Rezoning Petition Review

Date of Review: May 20, 2020 (***Revised September 17, 2020***)

Rezoning Petition #: 20-68

Location of Property: Approximately 8.5 acres located along the east and west side of Hedgemore Rd, south of Woodlawn Rd and west of Selwyn Ave.

DEVELOPMENT STANDARDS
Petitioner: Levine Properties, Inc
Rezoning Petition No. 2020-068
9/14/2020

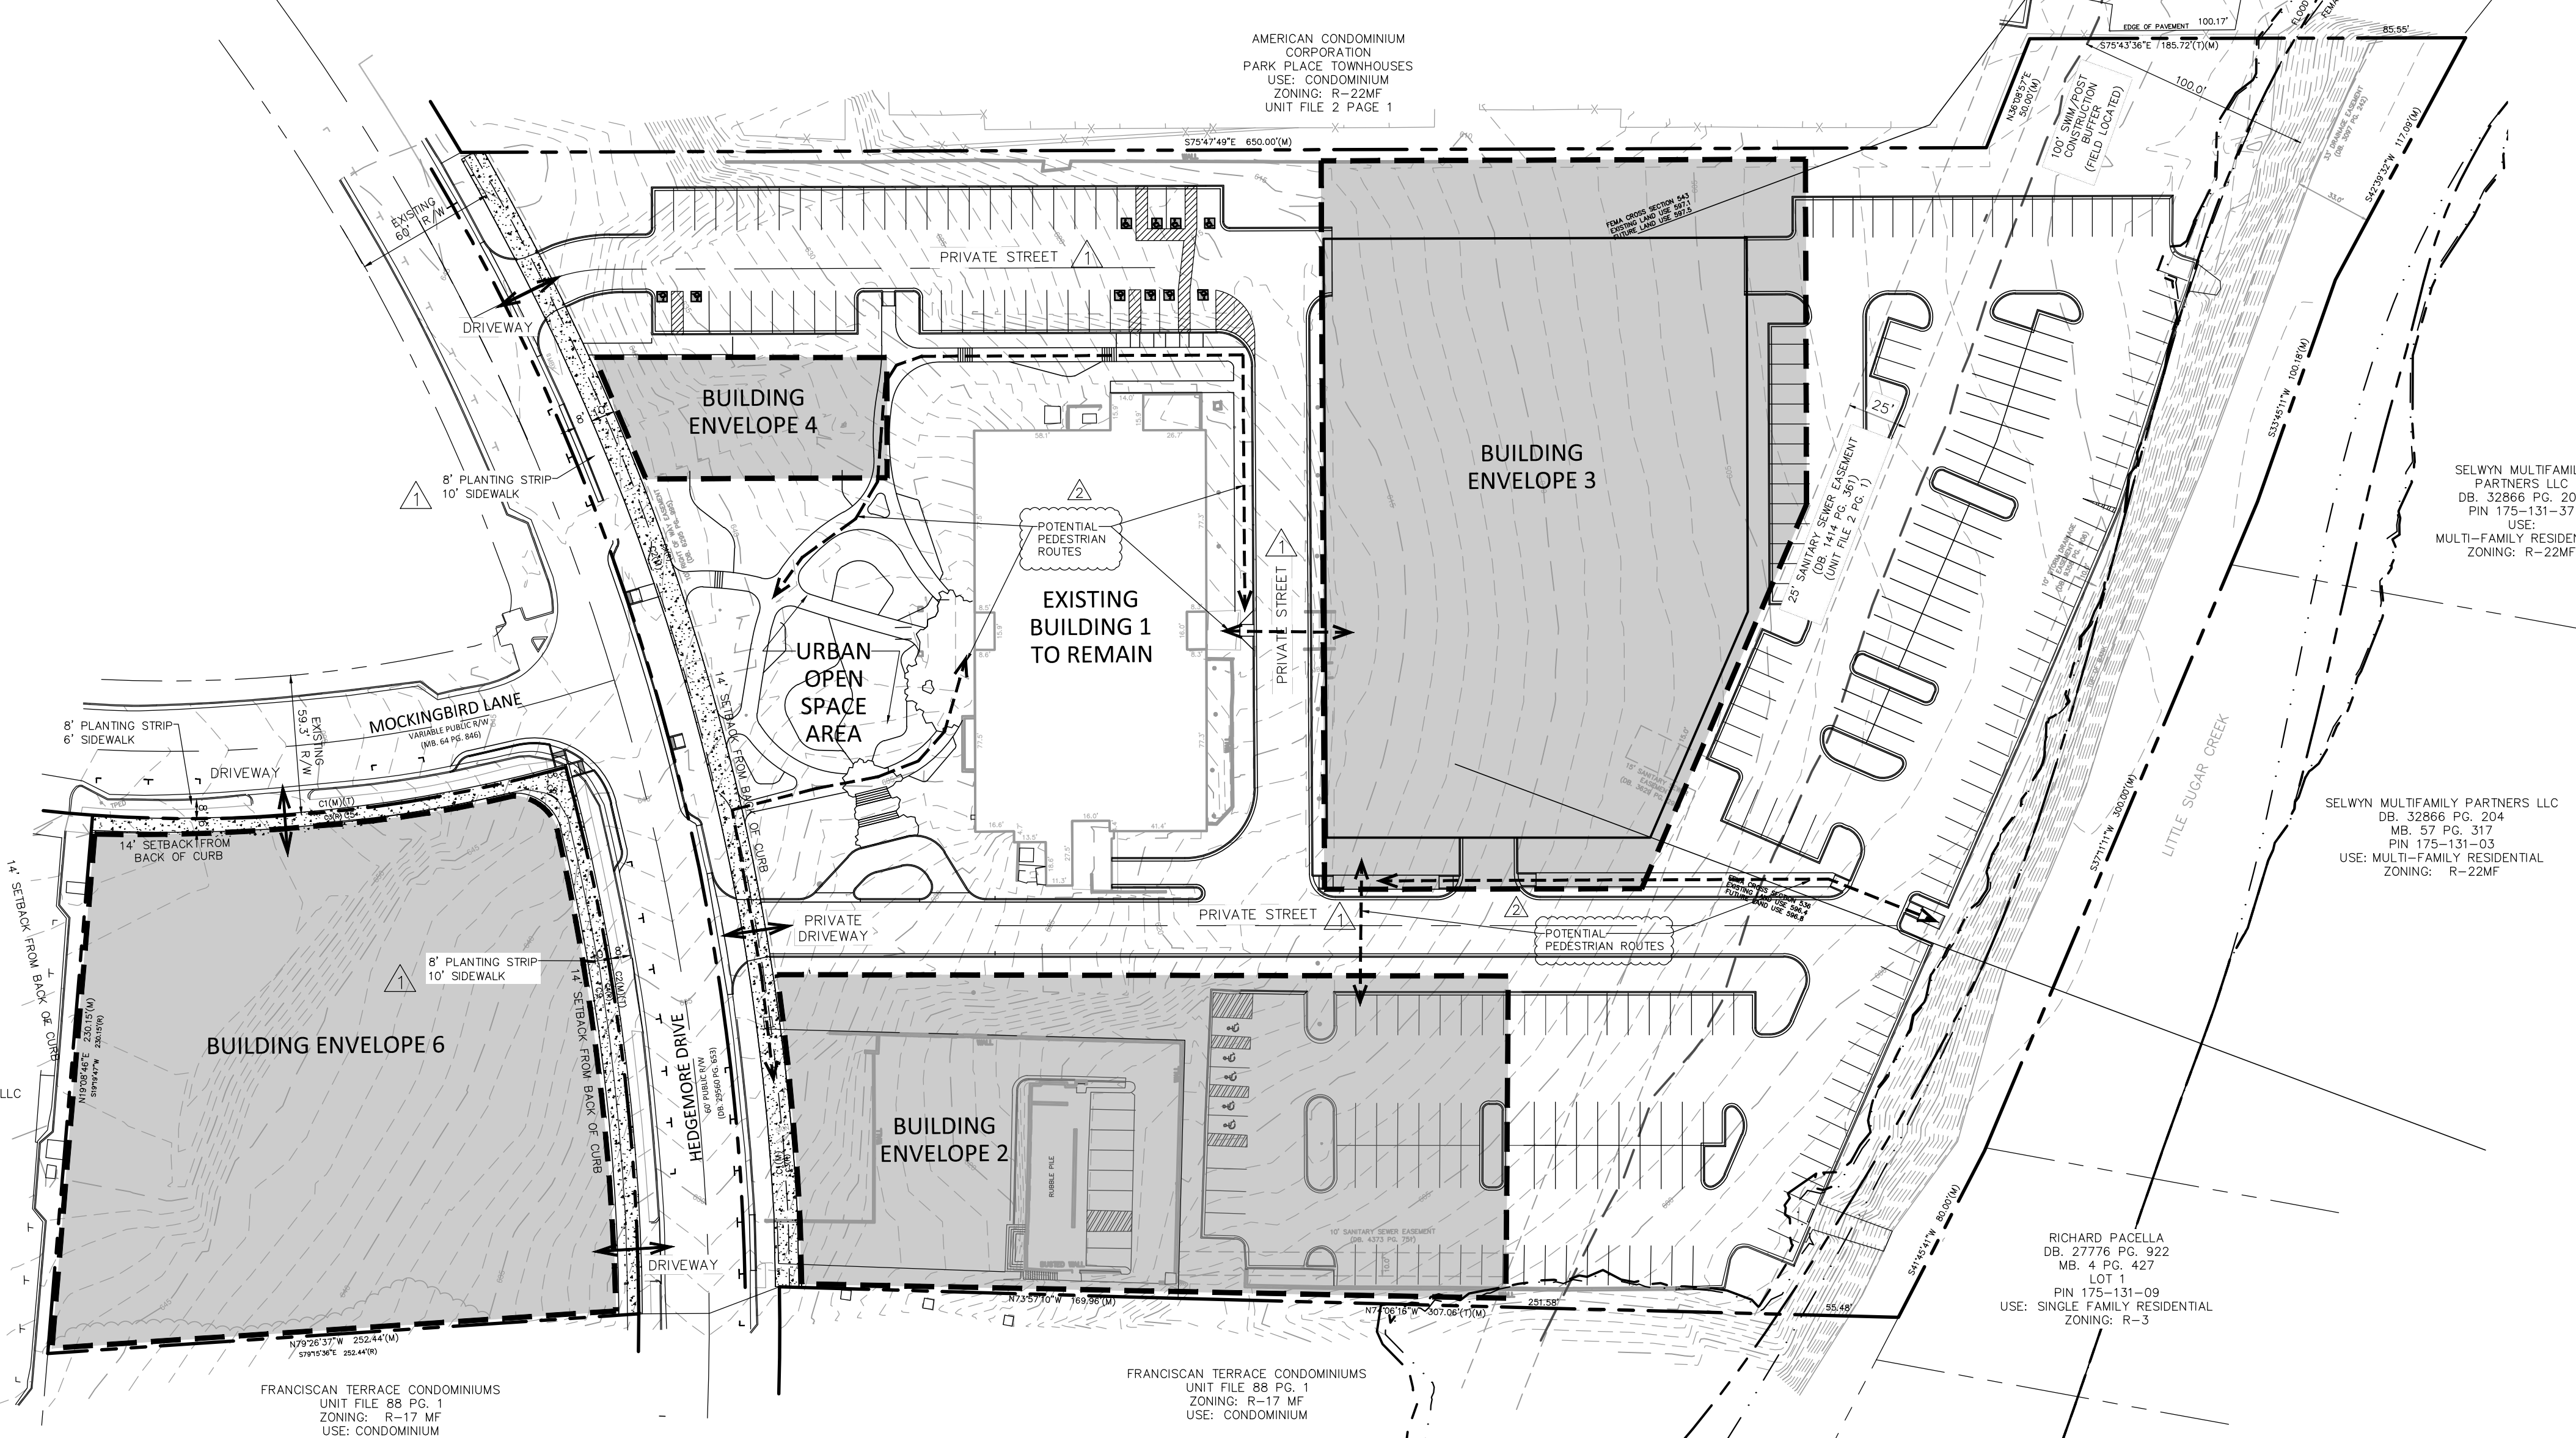
Please remove note “b” under *Environmental Features* in its entirety and replace with the following note: *Development within the SWIM/PCSO Buffer shall be coordinated with and subject to approval by Charlotte-Mecklenburg Storm Water Services and mitigated if required by City ordinance. Please note Stream Delineation Reports are subject to review and approval by Charlotte Storm Water Services.*
